I wish to object to the proposed Littleton Wind Farm development on the grounds that the application fails to adequately assess, address, or mitigate the existing and ongoing issues of littering, illegal dumping and fly-tipping in the Littleton bog area and surrounding road network. As per the attached evidence.

<b>TITLE:</b>	Amenity Tracks		
<b>PROJECT:</b>	Littleton Wind Farm		
<b>FIGURE NO.:</b>	4.7		
<b>CLIENT:</b>	Littleton Wind Farm DAC		
<b>SCALE:</b>	1:50,000	<b>REVISION:</b>	0
<b>DATE:</b>	09/04/2026	<b>PAGE SIZE:</b>	A3

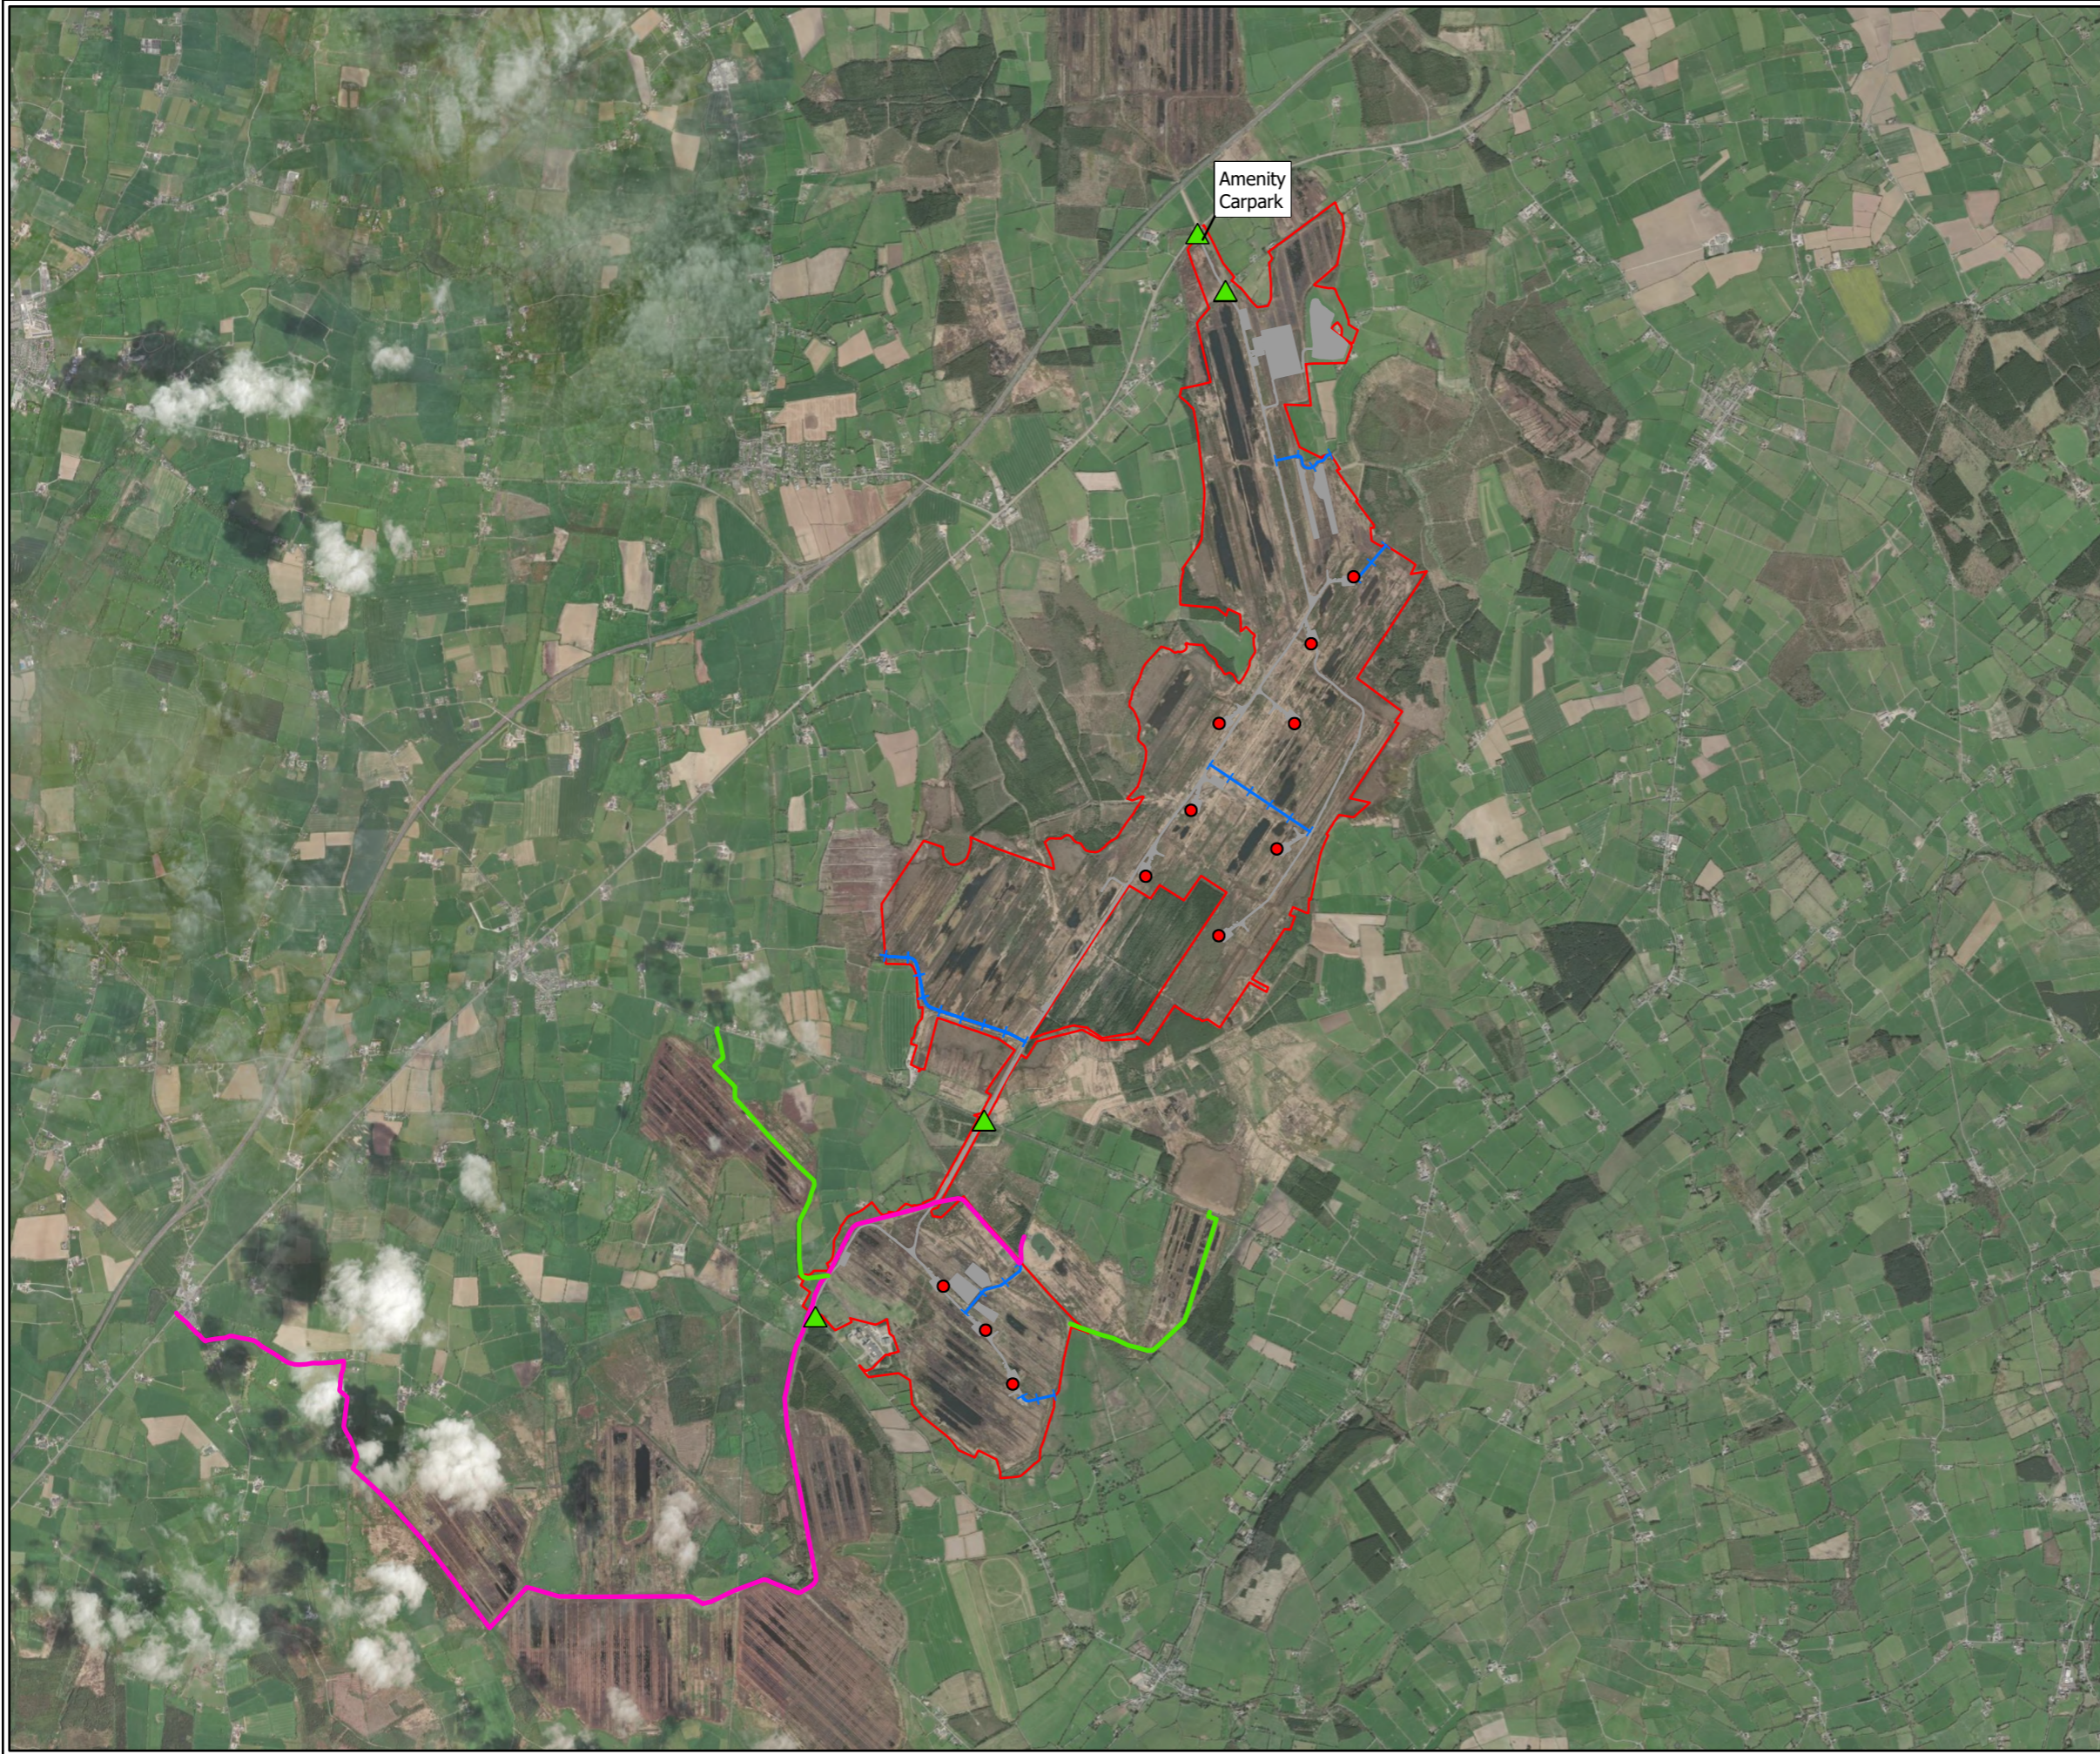
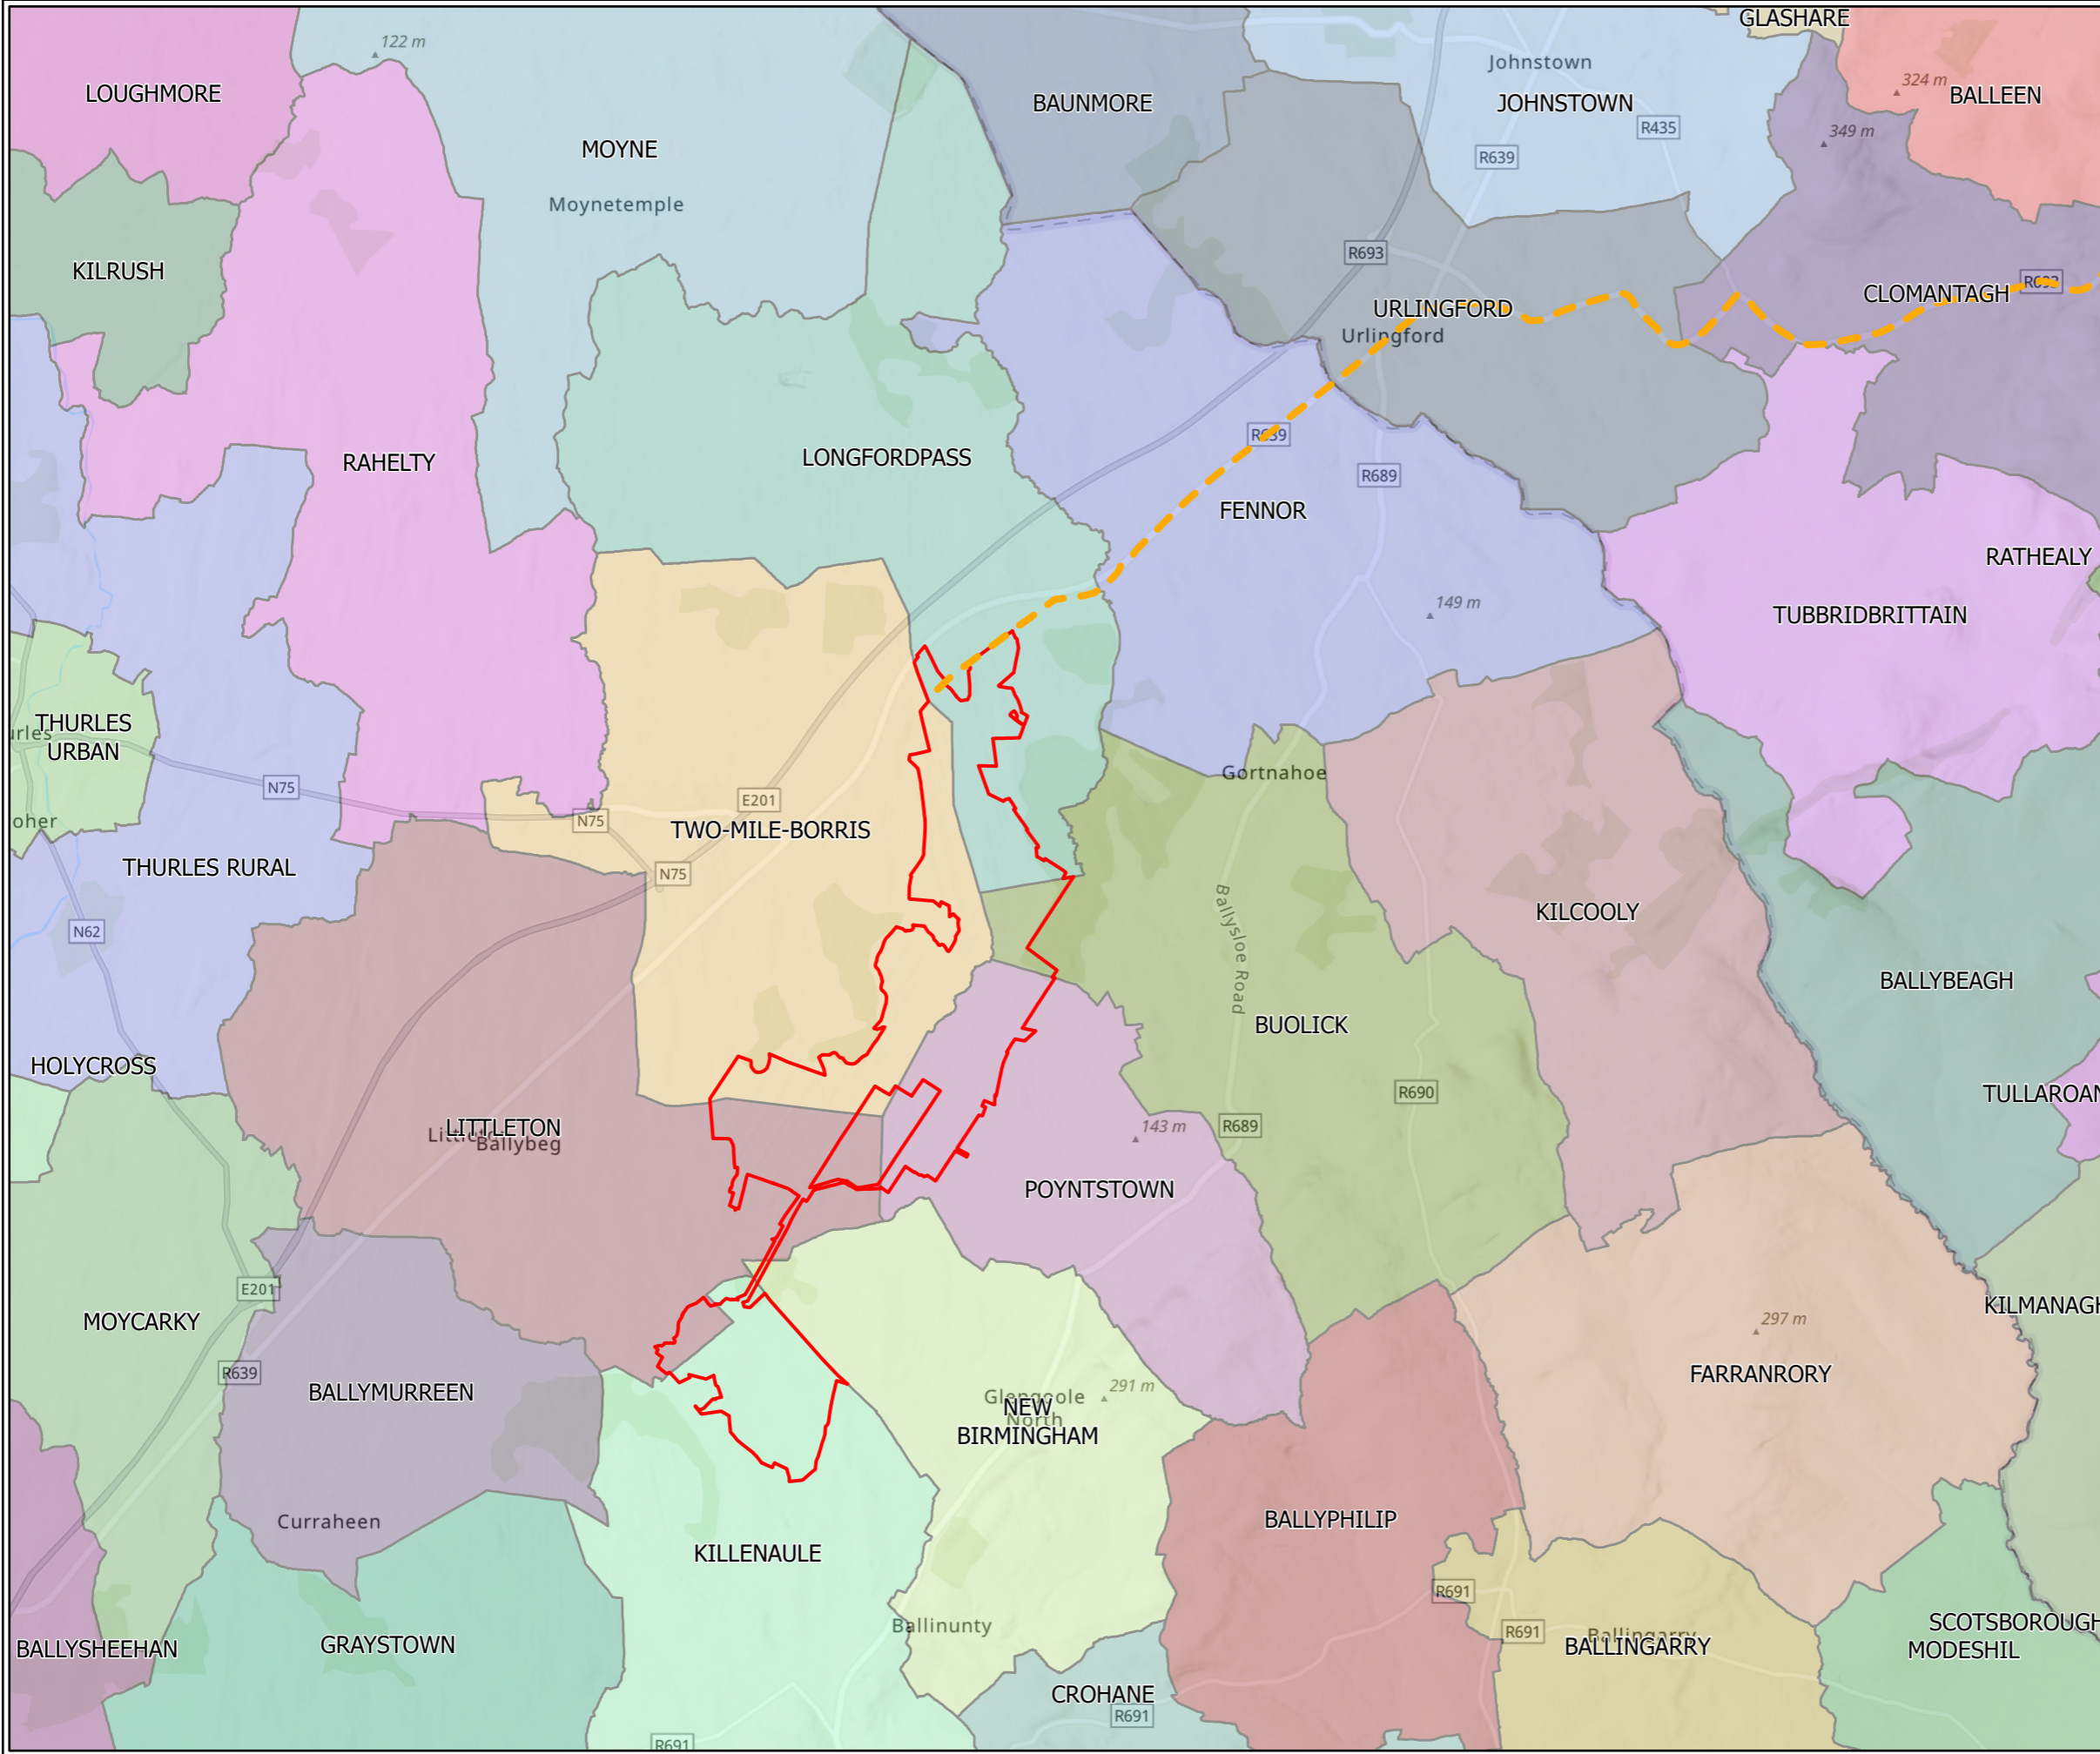
- Approximately 4 km of new walking and cycling trails.
- Additional visitor access infrastructure.
- New and upgraded access roads.
- Additional public parking facilities.
- Increased public access to previously less accessible bogland areas.

Despite these significant changes, the planning application contains no meaningful assessment of the likely effects of increased visitor numbers on litter generation, illegal dumping, or fly-tipping.

The proposed development would increase access to the boglands through:

- New amenity trails.
- New visitor infrastructure.
- Additional parking areas.
- Improved accessibility to remote locations.

These changes have the potential to significantly increase opportunities for:

- Illegal household waste disposal.
- Illegal dumping of bulky waste.
- General littering.
- Disposal of commercial waste.
- Disposal of garden and construction waste.
- Anti-social behaviour associated with isolated parking areas.

The application does not appear to contain any detailed operational strategy for managing litter or illegal dumping following completion of the development.

In particular, there is no clear information regarding:

- Public litter bins.
- Dog waste bins.
- Collection frequencies.
- Maintenance schedules.
- Monitoring arrangements.
- Inspection programmes.
- CCTV or surveillance.
- Enforcement measures.
- Reporting systems.
- Removal of illegally dumped waste.

1. A dedicated Fly-Tipping Prevention and Management Plan.
 2. A detailed Operational Litter Management Plan.
 3. A formal assessment of the effects of increased public access on waste generation.
 4. Identification of existing fly-tipping hotspots.
 5. Regular inspection and monitoring of trails and parking areas.
 6. Clearly defined responsibility for litter collection and illegal waste removal.
 7. Funding arrangements for long-term maintenance.
 8. Appropriate surveillance and enforcement measures where necessary.
 9. Annual reporting of fly-tipping and litter incidents.
 10. Assessment of impacts on habitats, water quality and protected species arising from litter and fly-tipped waste.
-
